CITY OF ALBUQUERQUE
PLANNING DEPARTMENT
DEVELOPMENT REVIEW BOARD

Project# 1006006
11DRB-70101 AMENDMENT TO PRELIMINARY PLAT

Project# 1006006

10DRB-70357 MAJOR - PRELIMINARY PLAT APPROVAL

**SIGHT DISTANCE DETAIL**  
NOT TO SCALE

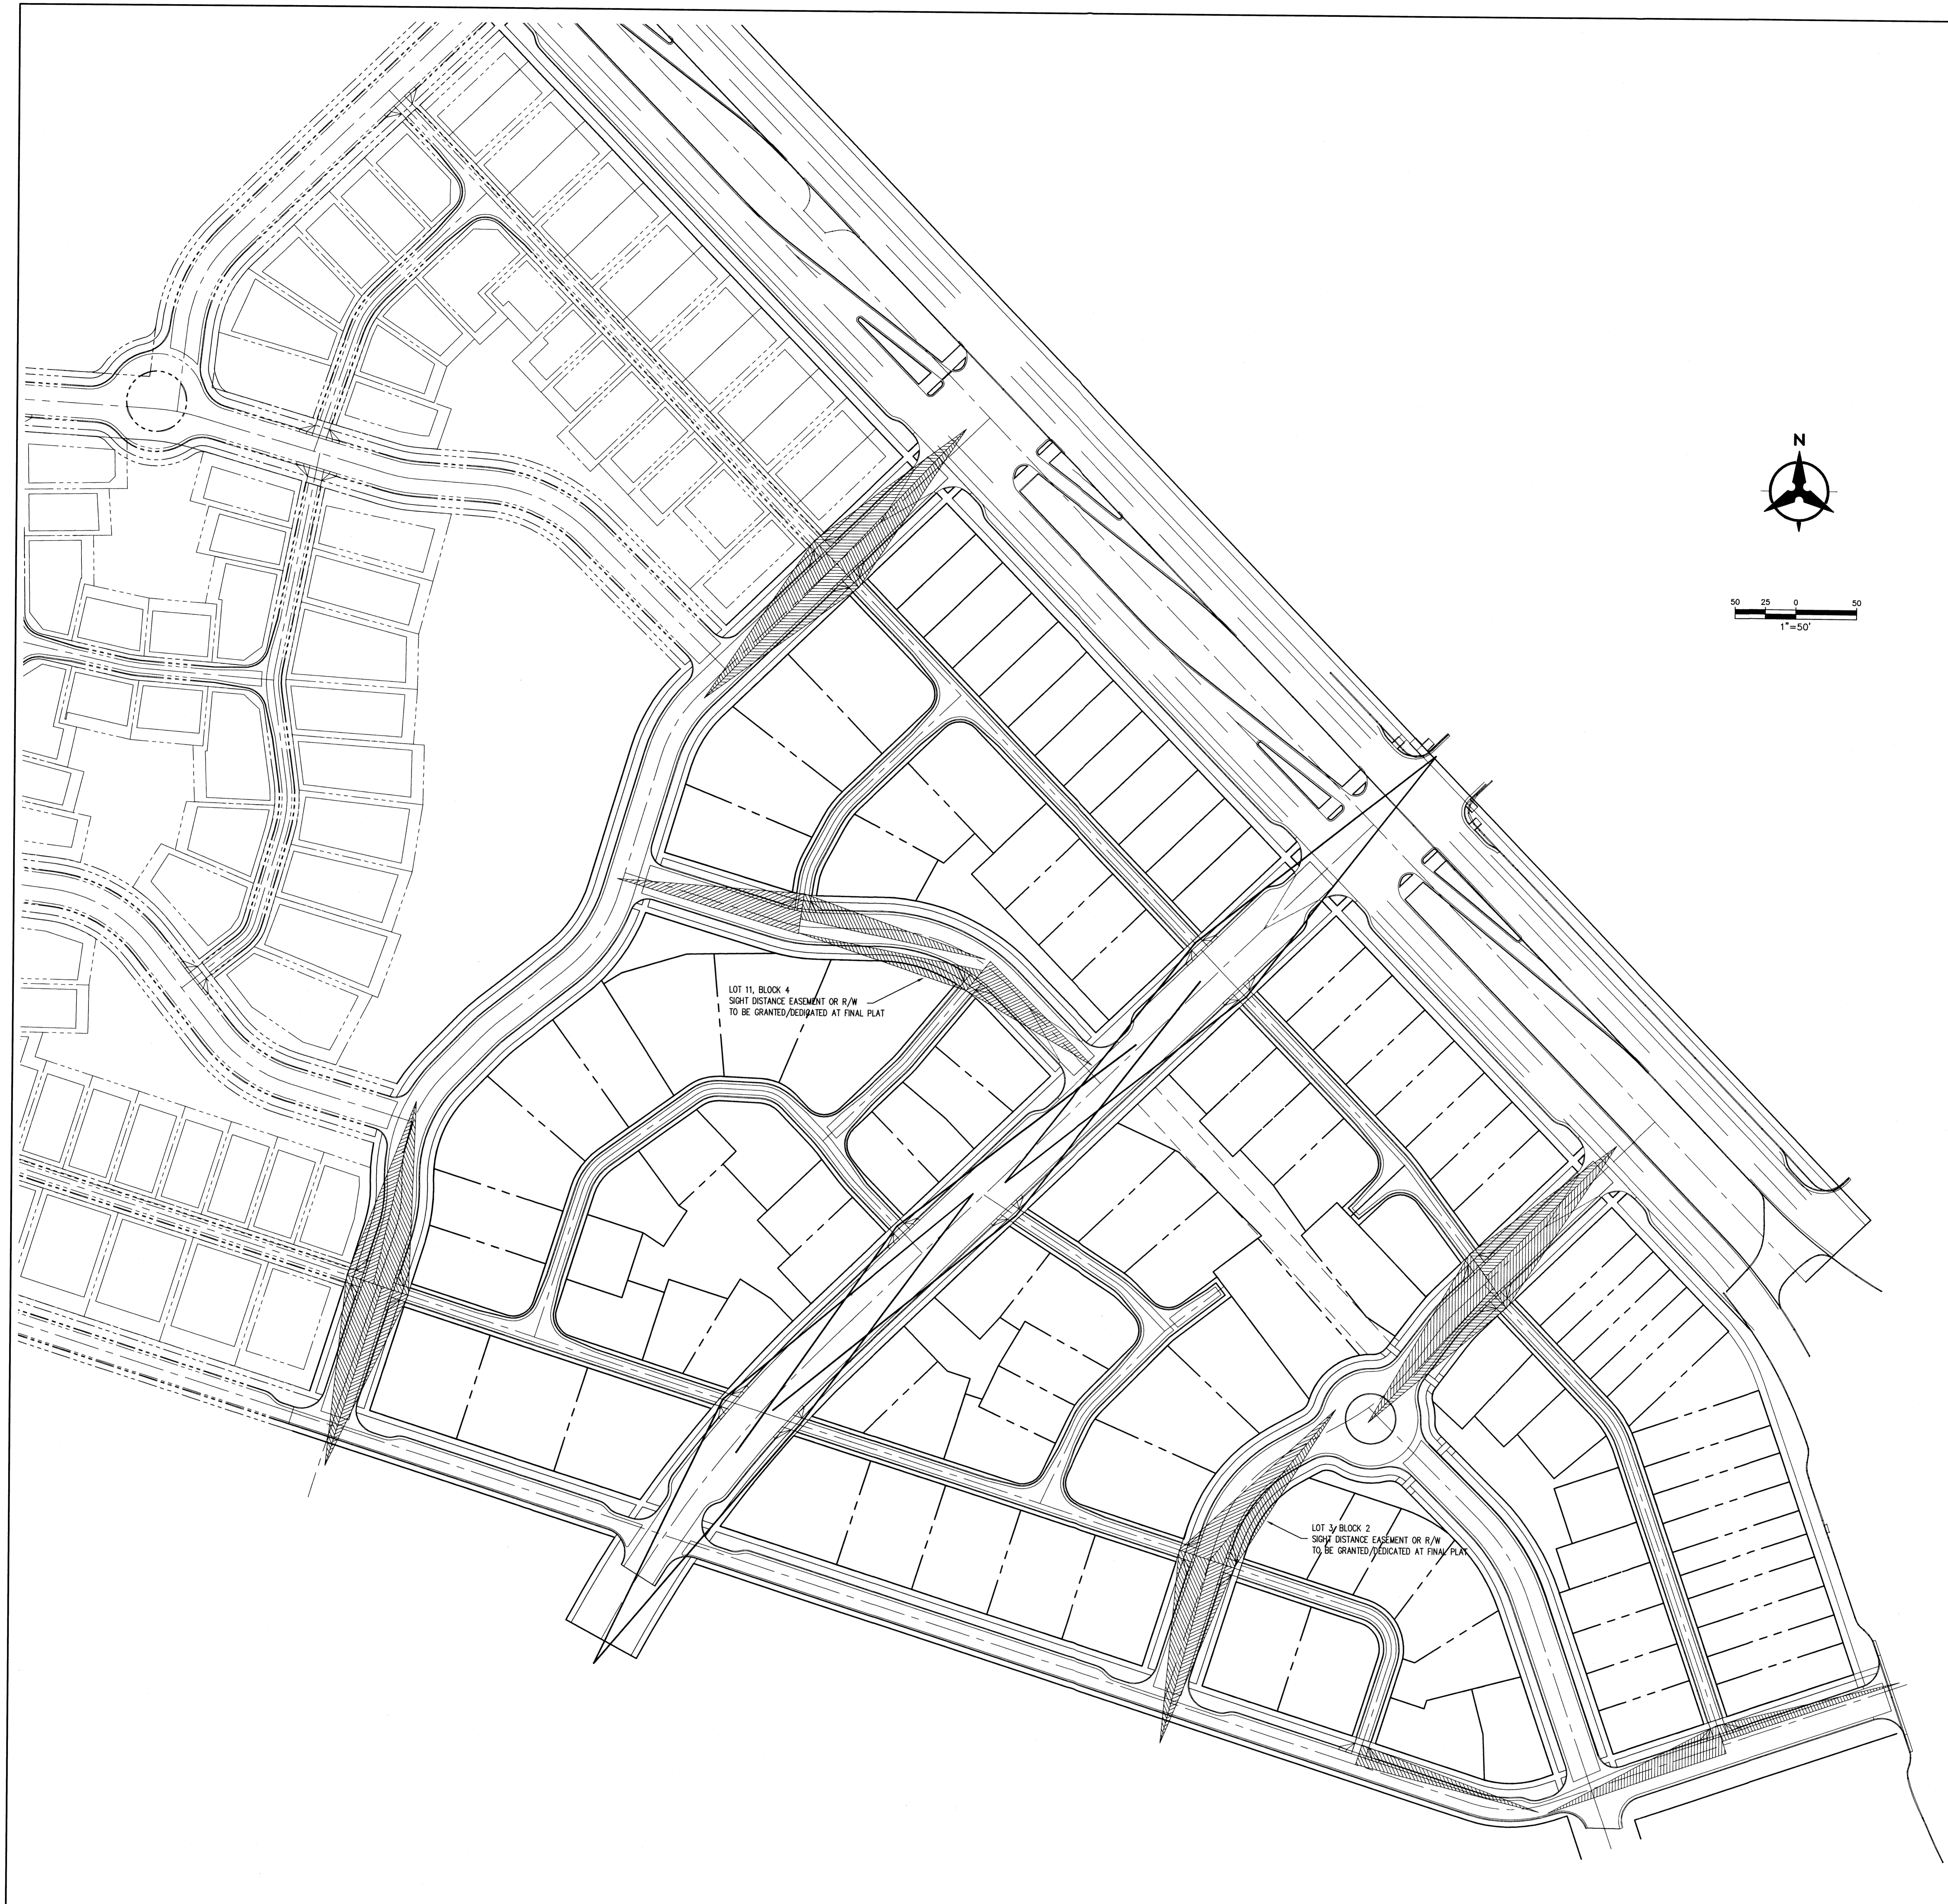
- Sight Distance Issues at Lot 11, Block 4 and Lot 3, Block 2 will be addressed with a right of way dedication or an appropriate easement.
